Planning Application Ref: M/111/18/T

Location: Hadley Close, Middleton on Sea, PO22 6PQ

Description of works: 1x Holm Oak - Crown lift by 6m, remove deadwood, crown reduction by 2-4m. 1x Box Elder - Crown lift 5m, remove boundary overhang by 2m, crown reduce by removing between 1-2m of branch end length to reshape and re-balance the crown

PLAN REF. 'MC1'

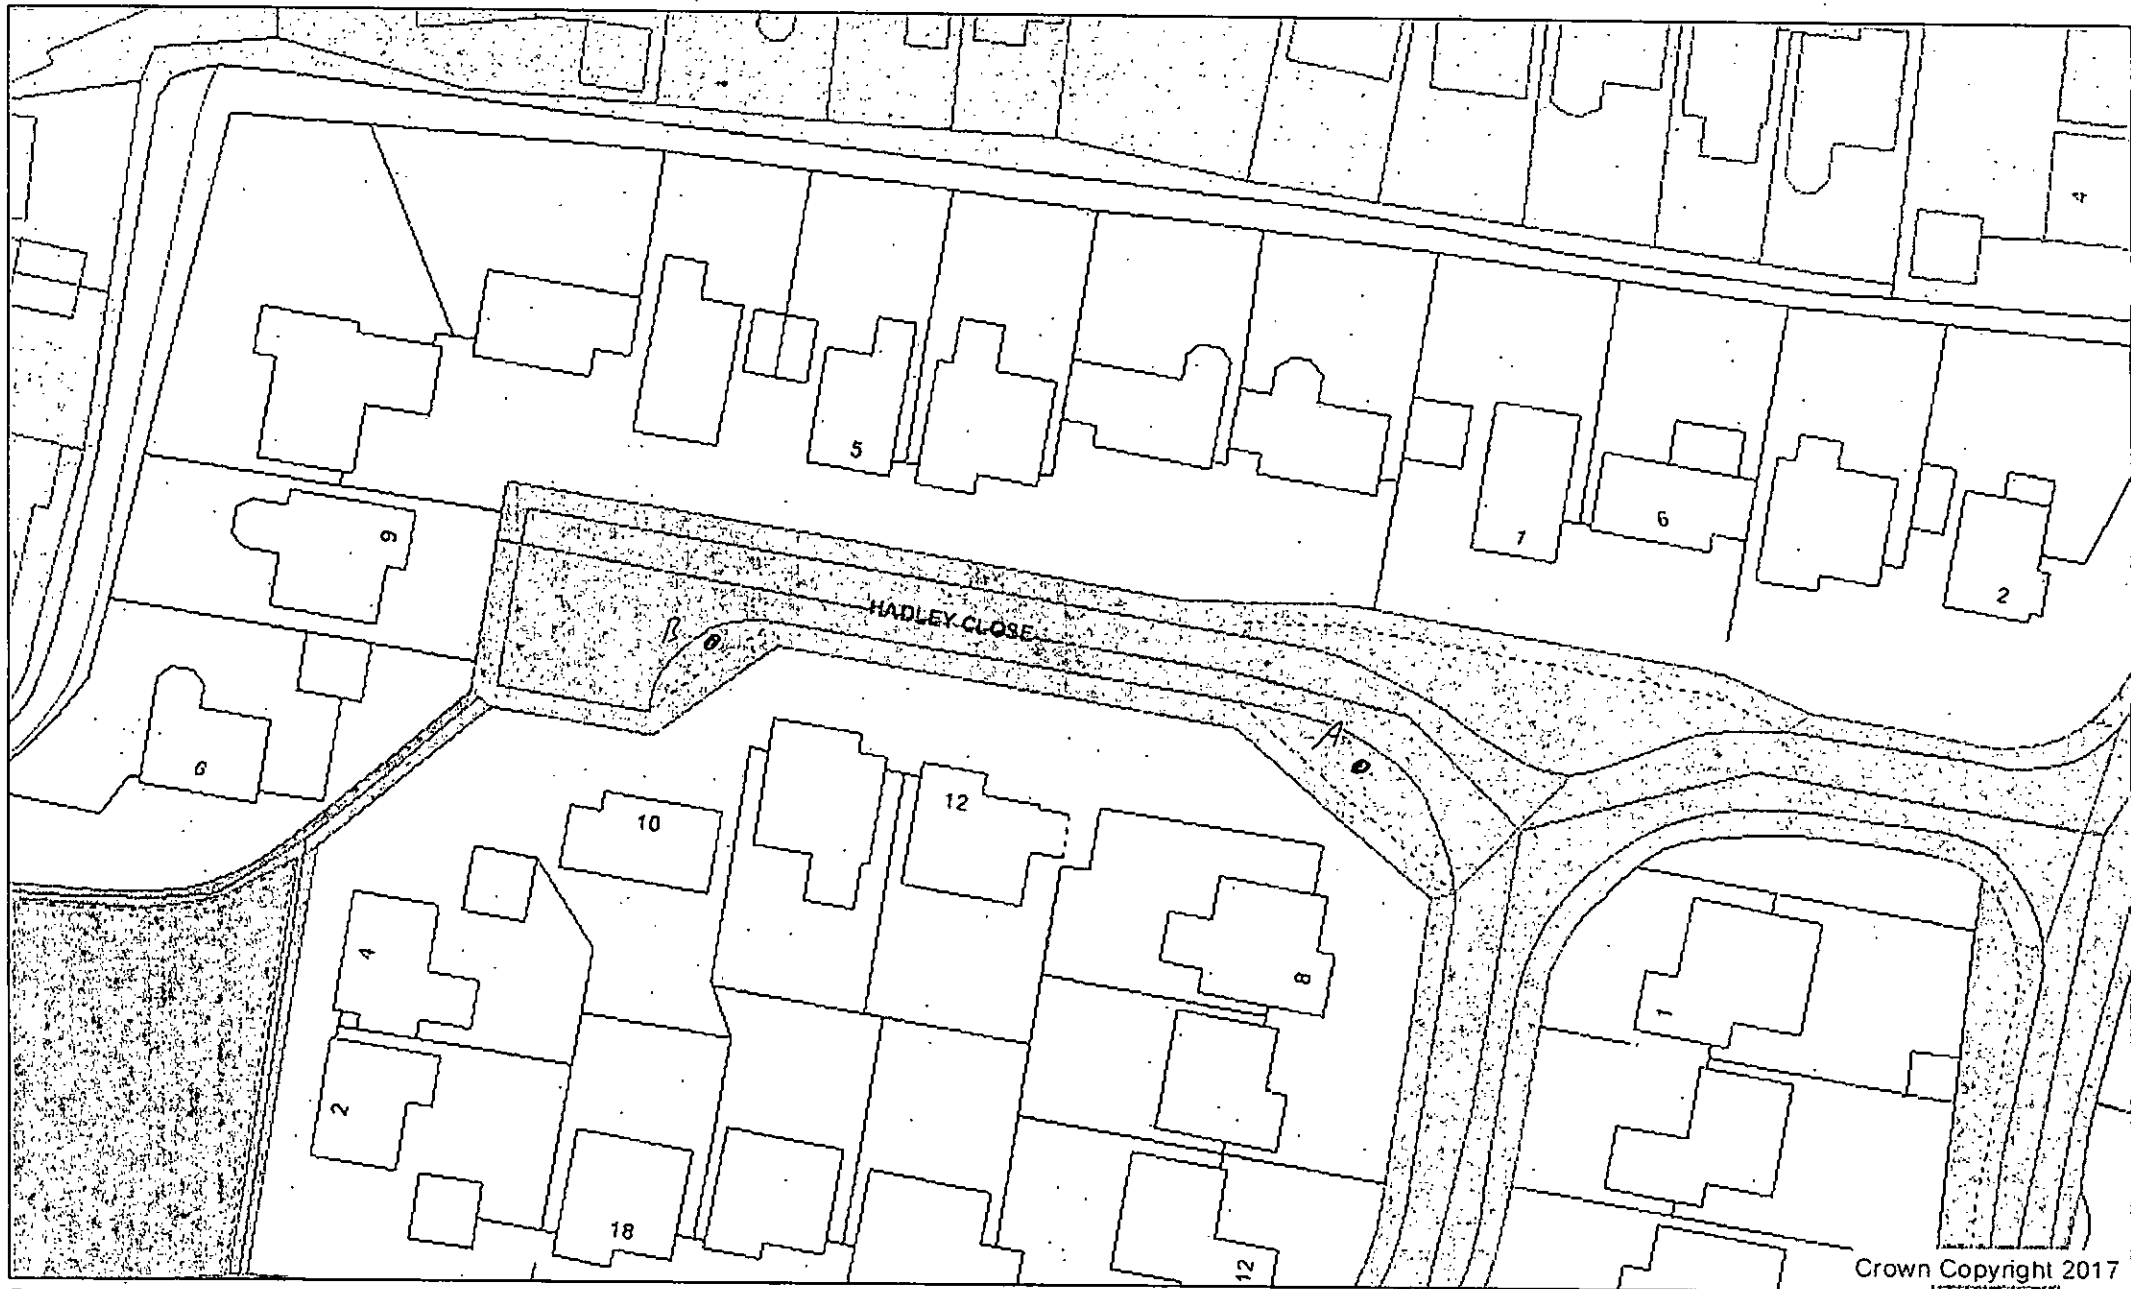
- Both trees appear to be healthy and stable with attractive crown profiles. They encroach low into the carriageway/footway and neighbouring property.
- TA is a large and prominent roadside tree. Its main stem has a number of active and redundant fungal brackets between buttress roots and all around the stem base. An accumulation of recently developed brackets have emerged between the main and subsidiary stem.

- The extent of decay has not been confirmed, although it is; identifiable, established, ongoing and around the stem – so is significant for hazard assessment. The tree is large and occupies a high-risk target area. It has a relatively unmodified crown with established low limbs and branches, although there is some discreet evidence of height reduction on several upper scaffold limbs/branches.

- TB is at the far end of the close in a narrow verge. It has spreading form and not an ideal tree-type for such a confined location. Some form of 'containment pruning' was a foreseeable requirement.

- TA - The work proposed is necessary to mitigate risk of structural failure and so justified on arboricultural grounds. While a temporary loss of aesthetic value is inevitable, satisfactory canopy renewal and recovery should occur if the work is undertaken to a high standard and at an appropriate time of year.
- TB - The work proposed is justified and if undertaken to a high standard will not incur a noteworthy loss of amenity value to the surrounding area.

- I recommend **CONSENT** for this application, subject to the following condition:

- Where whole branches are to be removed and final cuts made close to the trunk or branch union they are to be made as shown in Figure 2 of BS3998:2010

- Where branches are to be shortened back the final cuts are to be made at the correct angle shown in BS3998:2010 and adjacent to a live bud or lateral.
- TA - The removal of crown material which has developed since the last operation must be done sympathetically and with respect to established 'knuckles' so as not to extend beyond the point of origin.
